Outline application for access only - mixed use development comprising of up to 400 dwellings, a care home with up to 70 beds, a Local Centre comprising up to 2000sqm of A1/A2/A3/D1/sui generis floorspace, provision of land for a 1FE primary school (with sufficient space to ensure that it is expandable to 2FE), provision of land for a scout hut, safeguarding of land to help link the site to the Pagham Harbour Cycle Route & other community uses including public open space & allotments with some matters reserved. This application is a Departure from the Development Plan

Land South of Summer Lane & West of Pagham Road Pagham

Thank you for your internet representation made on 31st March 2017 which has been recorded as '**no objection**' with the comments as follows:

Figure 5.2 – Proposed northern site access junction

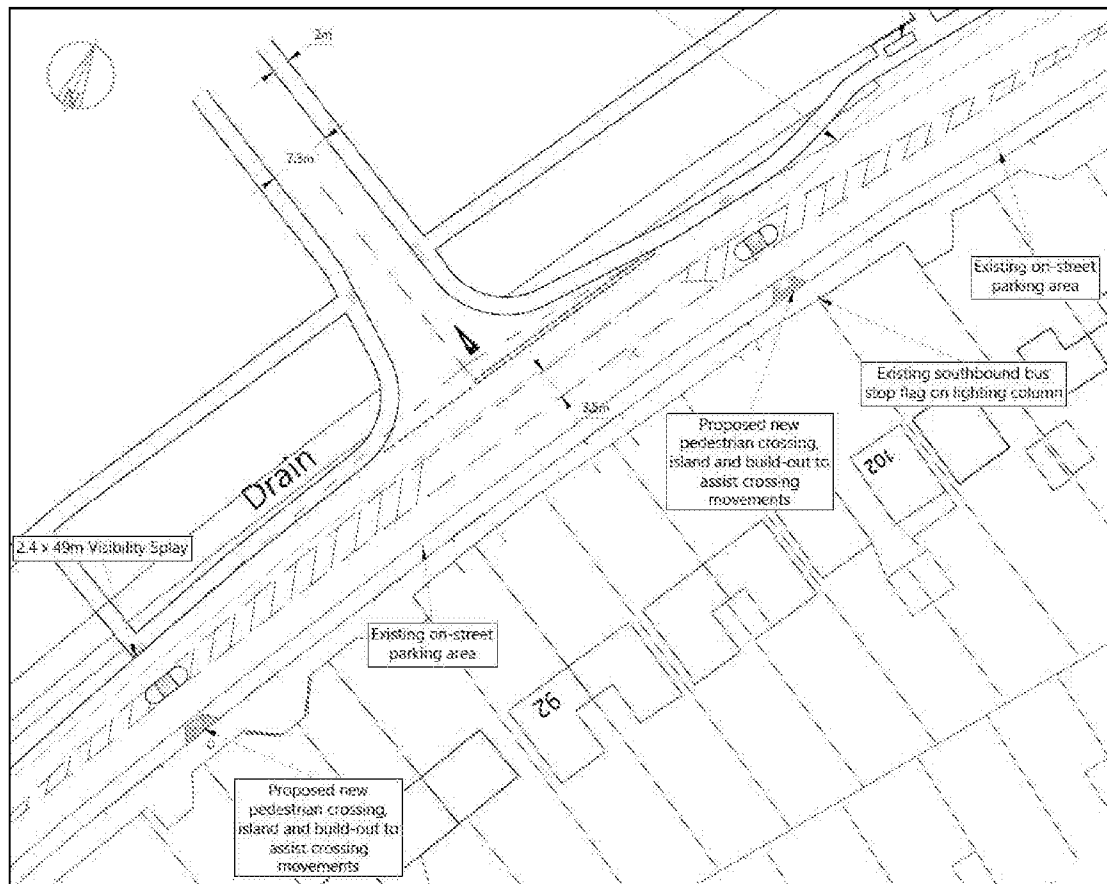
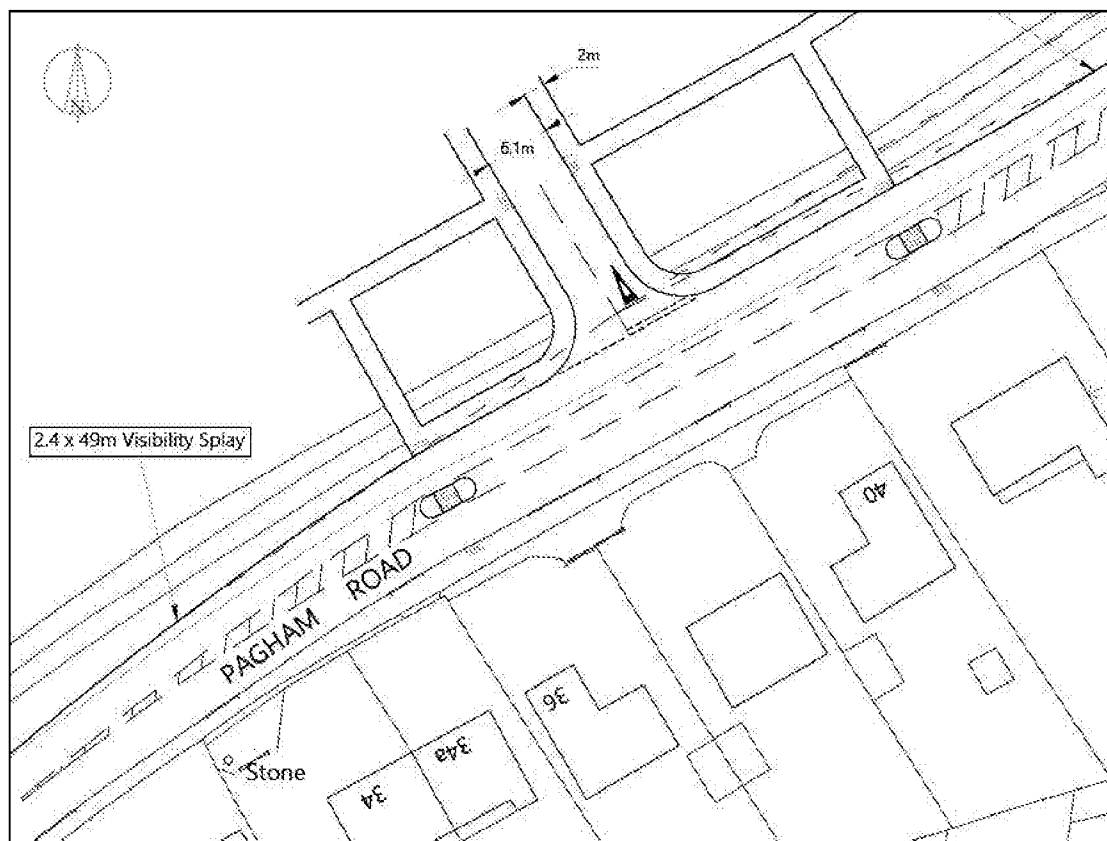
2. It is further suggested that the road-side part of the development, include an on-road cycle path alongside the pedestrian walk way, ideally giving priority to pedestrian and cyclists for motorised vehicles at the points of crossing into the development. This would mean a double give-way lines as vehicles left the site and encourage drivers to carefully

Figure 5.4 – Link to Pagham Harbour cycle route

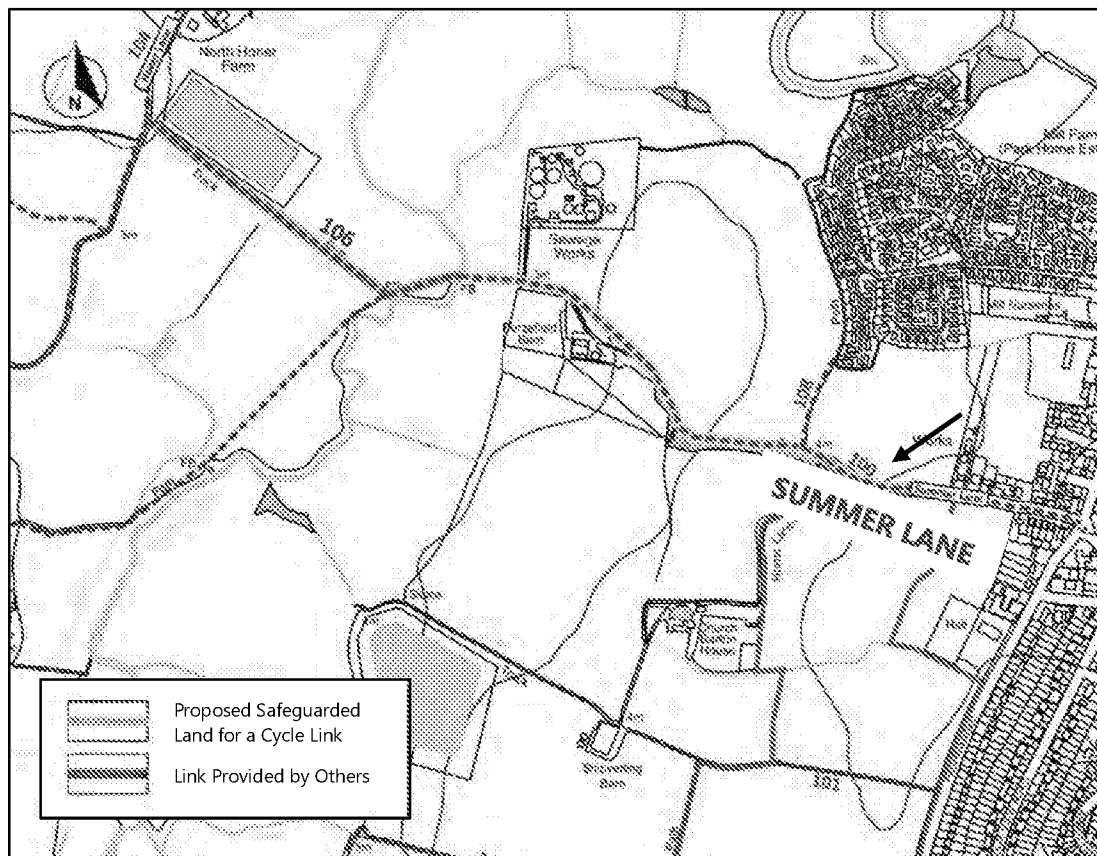
I note that this outline design very helpfully includes cycle routes across the development, and annotates the off-road cycle route from Summer Lane to Homer Lane (which eventually would become part of Sustrans long-distance coastal route NCN2). This is a route set as high priority by the Bognor Cycle Forum in consultation with WSCC.

1. It would be good if this development served to upgrade the footpath to Homer Lane and formalise this part of NCN2, to Homer Lane. This path would then pick up the road/track to South Mundham and enable WSCC to open up the whole route to Chichester
